**Consultation Response from KC,
 Policy**
2020/91896 Pentlands, New Mill Road, Holmfirth, HD9 7LN
Demolition of existing dwelling and erection of 25 dwellings with associated access and external works
Date Responded: 05/08/20 Responding Officer: TB/AL Responding Ref:

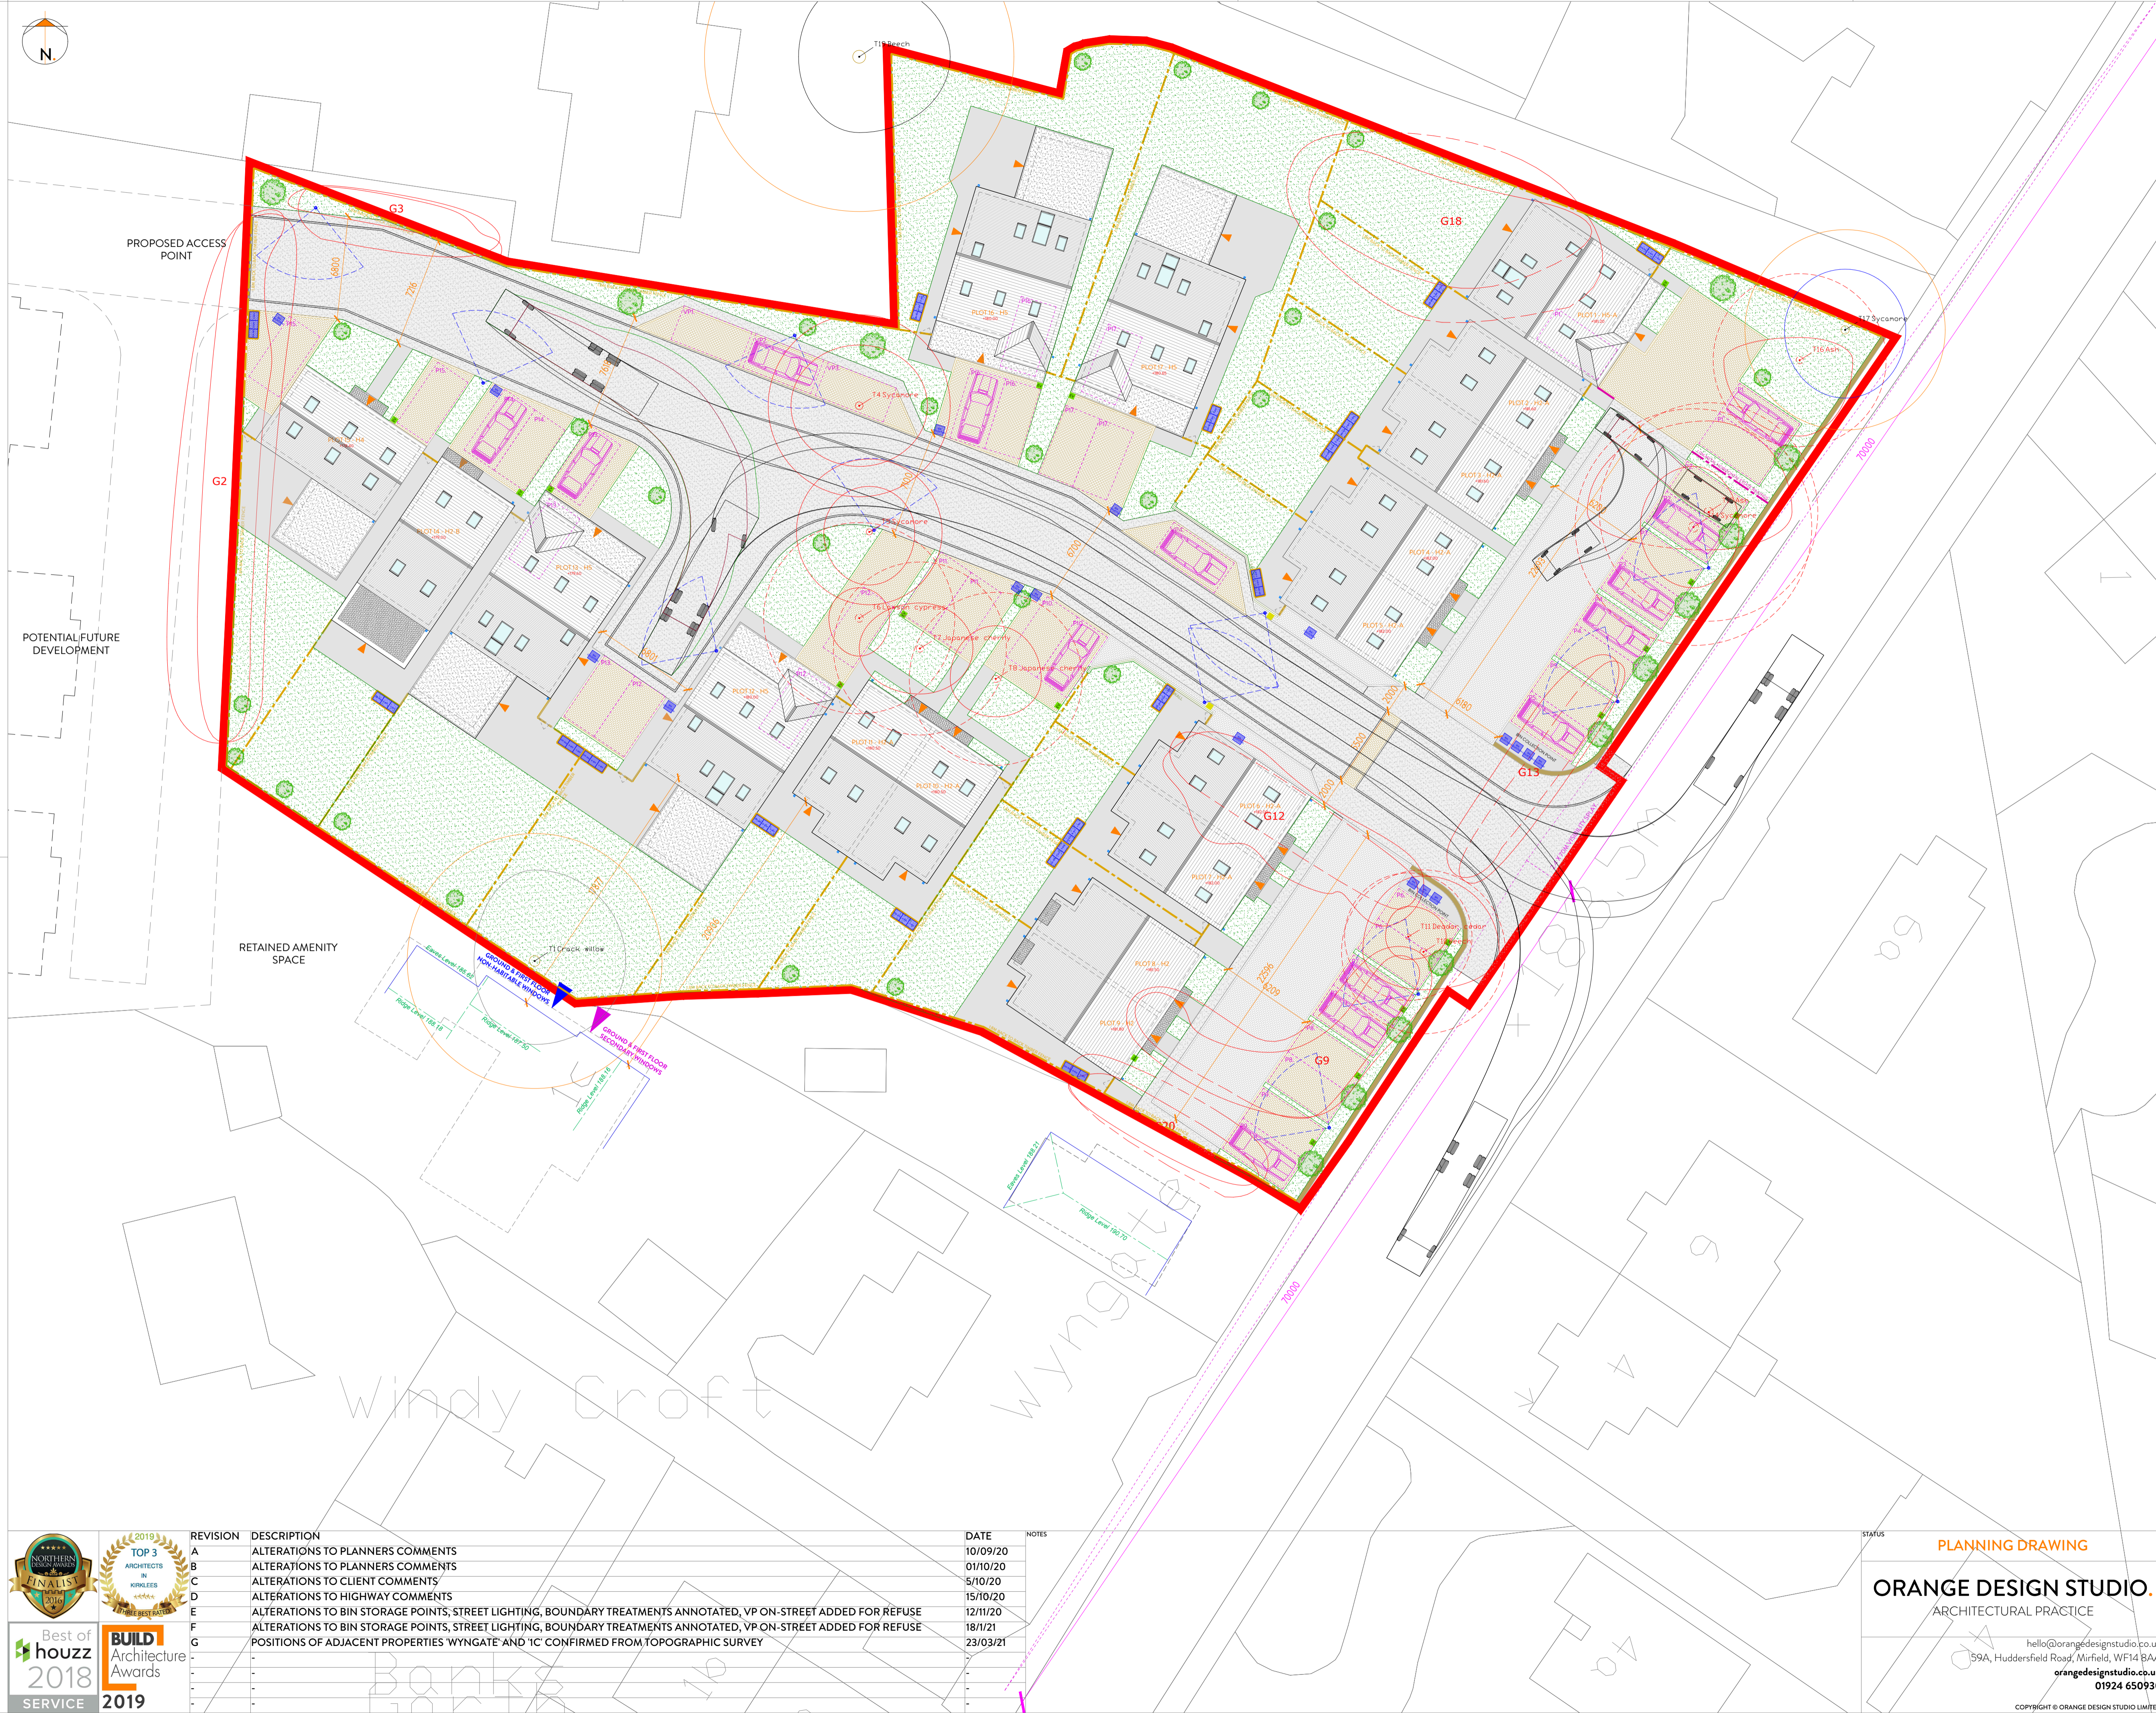
There appears to be no open space provided as part of this proposed development. The above assessment identifies existing deficiencies in the provision of existing park/recreation grounds, natural/semi-natural greenspace, allotments and amenity greenspace in the area. Provision for these types of open space should therefore be provided in accordance with policy LP63 and a proportionate provision for a Locally Equipped Area of Play (LEAP) is required. The Landscape Team should be consulted for their views on the need for quality improvements at Sands Recreation Ground and whether a financial contribution towards the improvement of existing play facilities within the area would be more appropriate in lieu of on-site equipped play provision.
